Reference No:	2021/62/94082/W
Site Address:	26, Stratford Close, Golcar, Huddersfield, HD7 4BU
Description:	Erection of front dormer extensions with side single storey and first floor extensions and new porch enclosure
Recommending Officer:	Tom Hunt

DECISION – Full Conditional Permission

Officer Report

2021/94082 – 26, Stratford Close, Golcar, Huddersfield, HD7 4BU

Proposed Site Plan
1 : 100

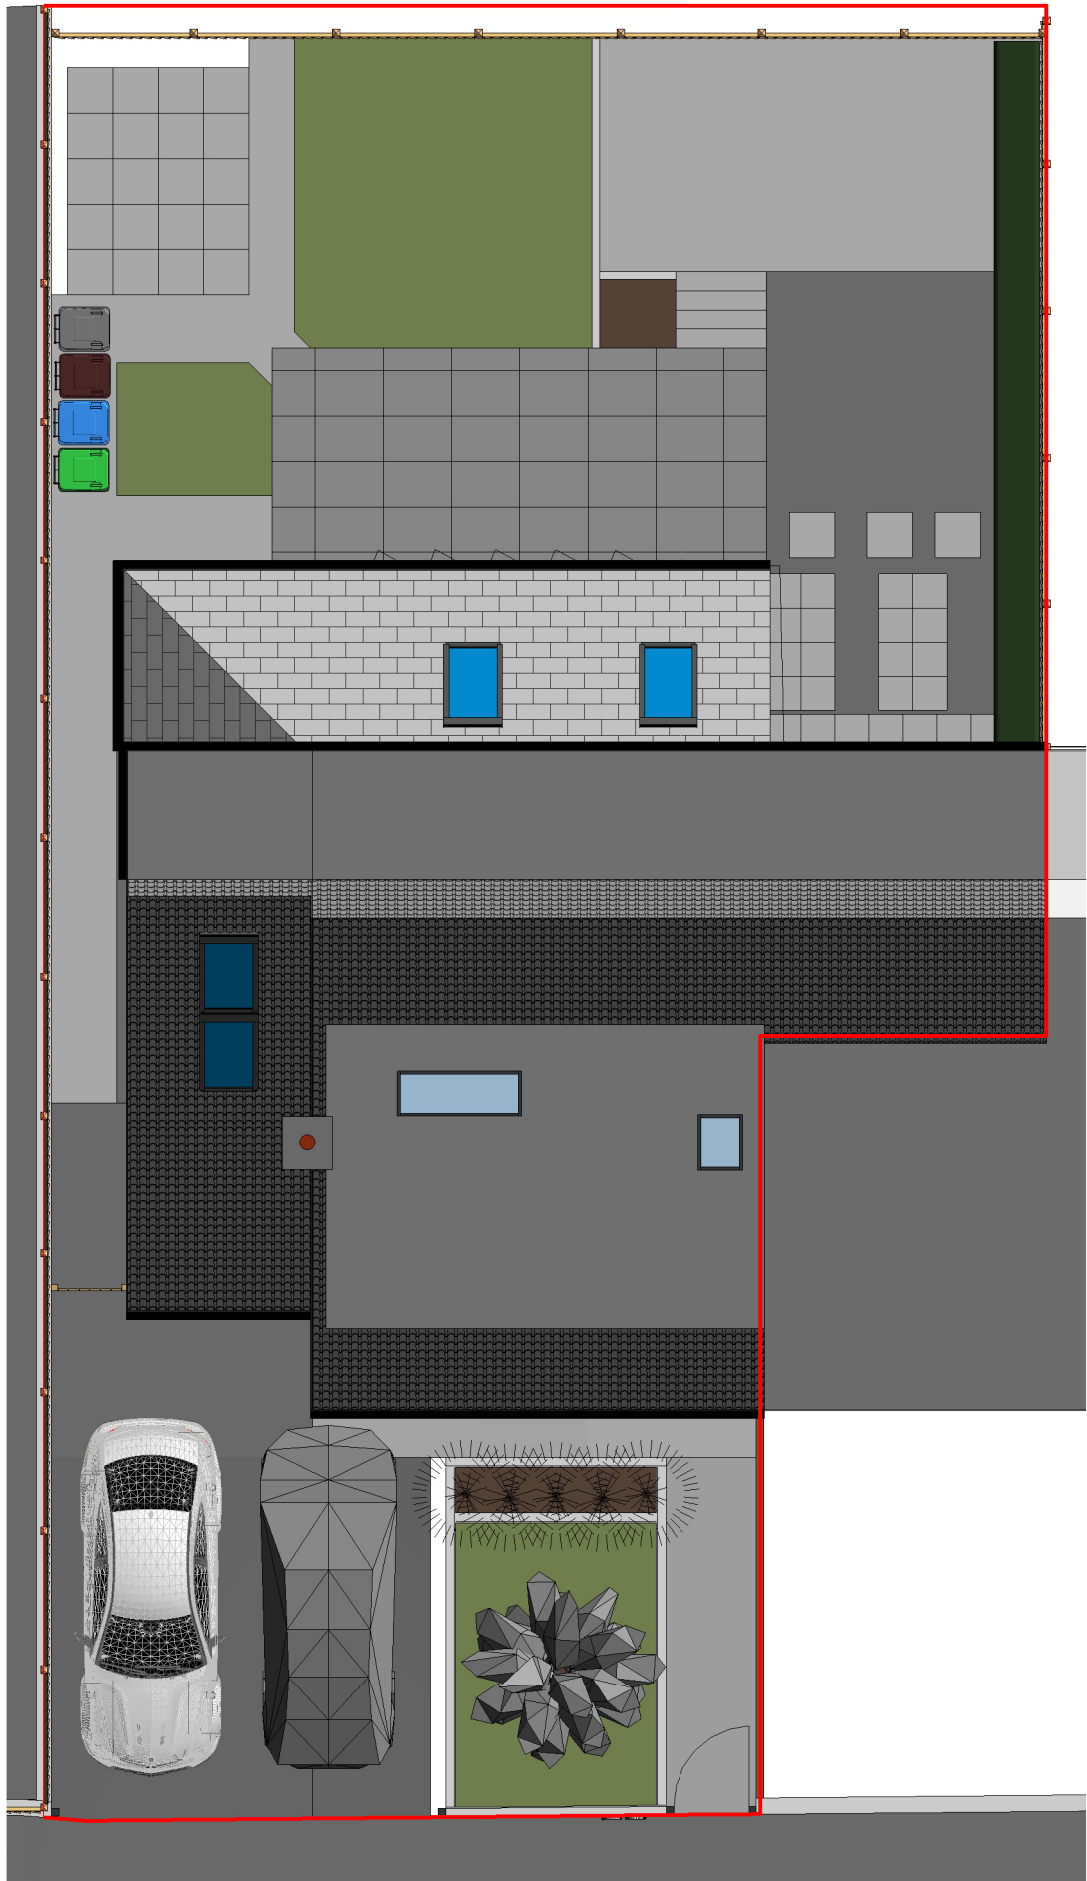
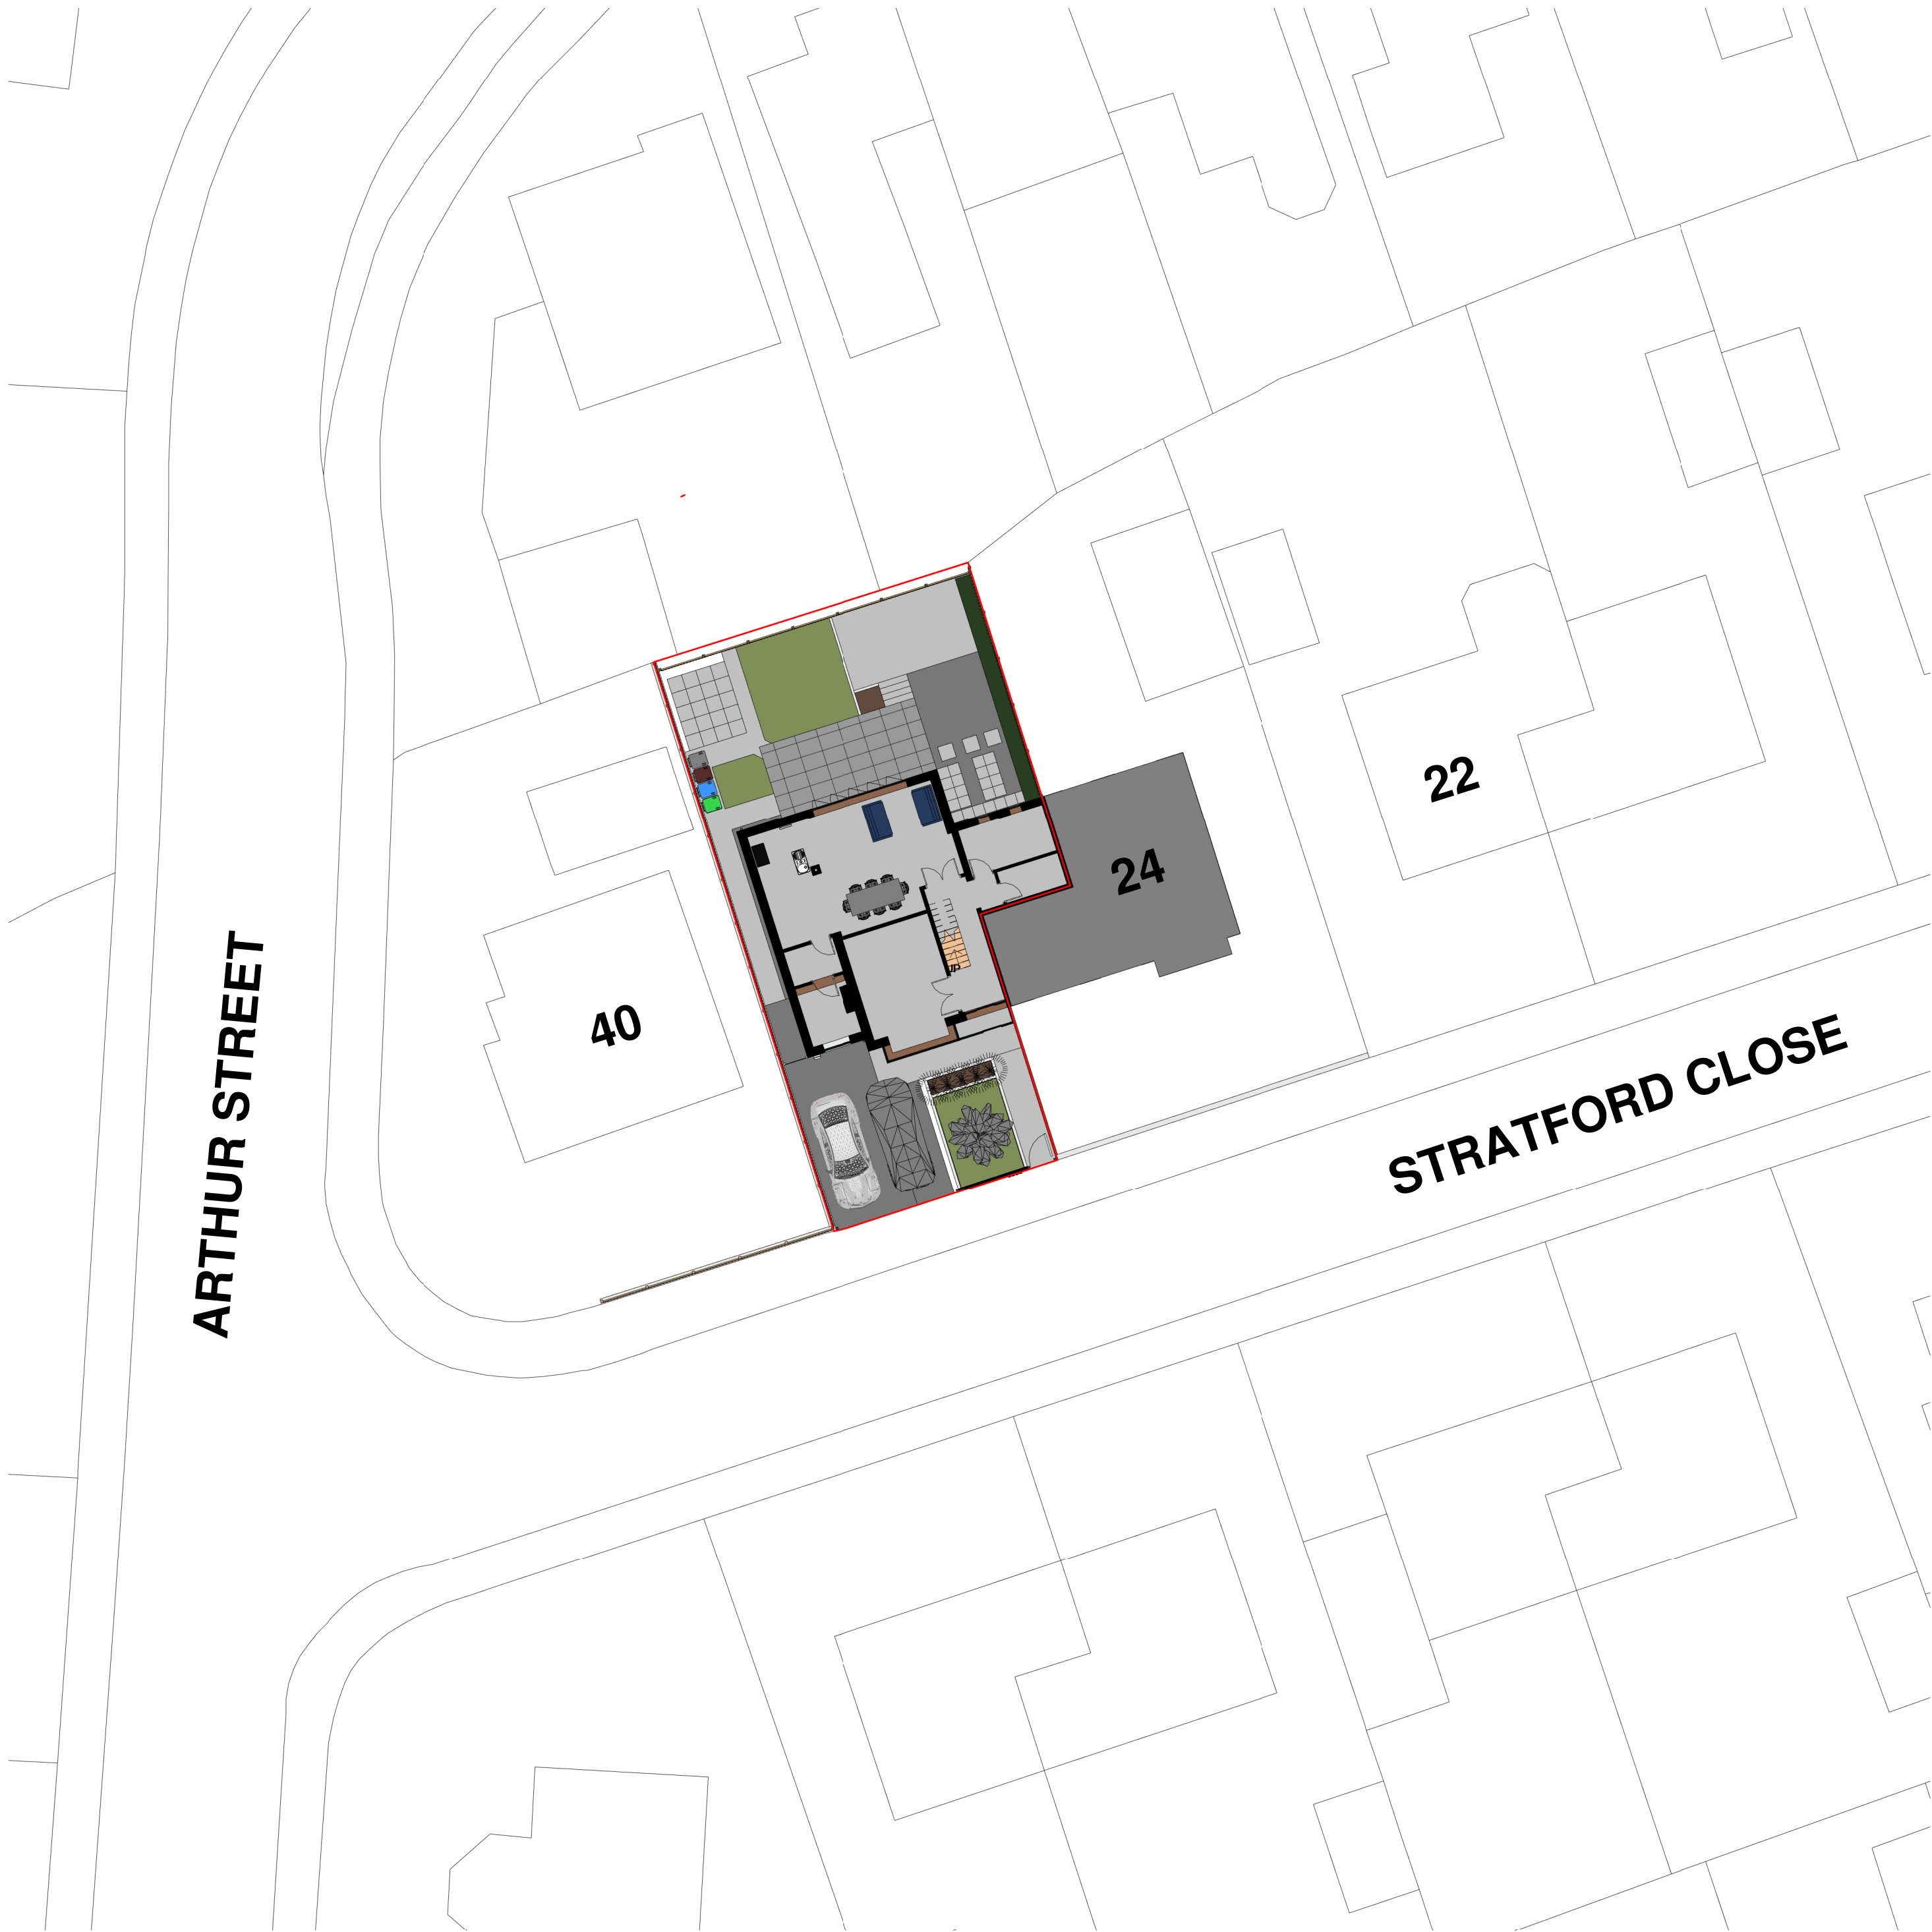
Two parking spaces will serve (one new) the property with its increased bedroomming but would retain a small section of soft landscaping to the front.

The policies seek to ensure that new developments have an acceptable impact on highway safety and provide sufficient parking. Whilst the proposed development would intensify use with the addition of a bedroom, it would improve the current off street parking provision within the site adding one more off street parking space and comply with the Highways Design Guide to avoid additional harm to highway safety. The scheme also includes the provision of gates to ensure that these do not obstruct the highway they will be conditioned to open inwards only.

3. Prior to the hereby approved extension being first brought into use, the two parking spaces outlined in red on the hereby approved plan entitled 'Proposed GF and FF Plans. Project No. 2021-1497. Drawing No. P202. Revision: A' shall be provided, and shall be laid out with a hardened and drained surface in accordance with the Communities and Local Government; and Environment Agencies 'Guidance on the permeable surfacing of front gardens (parking areas)' published 13th May 2009 (ISBN 9781409804864) as amended or any successor guidance. Notwithstanding the provisions of the Town and Country Planning (General Permitted Development) Order 2015 as amended (or any Order revoking or re-enacting that Order) these areas shall be so retained, free of obstructions and available for the parking of vehicles.

Proposed Roof Plan
1 : 50

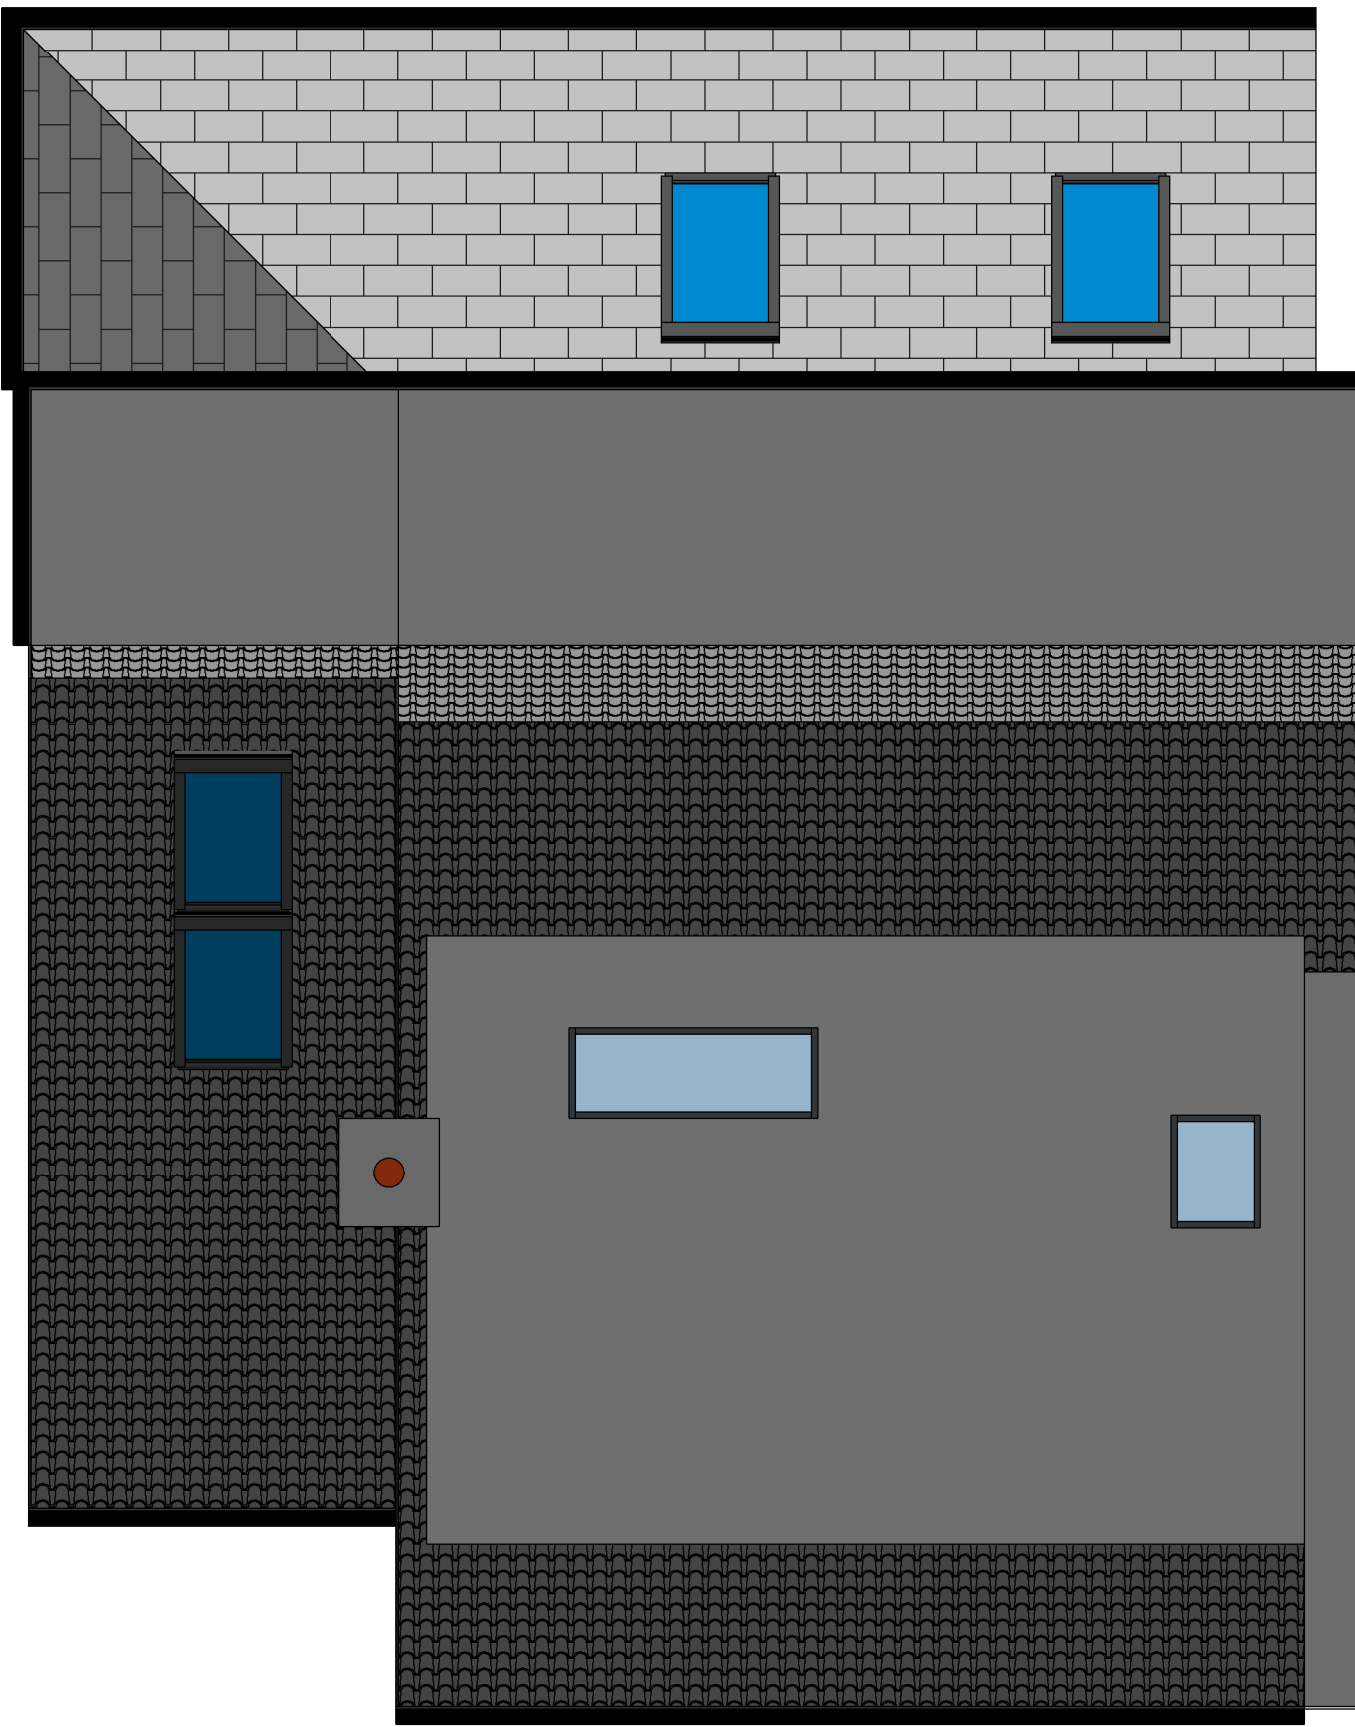
The front dormer's size and scale is considered in relation to the existing dormers within the streetscene; it is acknowledged that the present dormers found are large and dominate the front roof elevations of their hosts which would not be compliant with the adopted 'House Extension and Alterations SPD' however in this specific context, Officers regard that the proposal would sufficiently harmonised with the streetscene with modern, standing seam metal cladding blending in with the grey concrete roof, being set back considerably from the eaves of the host, set down from the roof ridge height and to have a flat roof aiding in the dormer being in keeping with the street scene's current large front dormers.
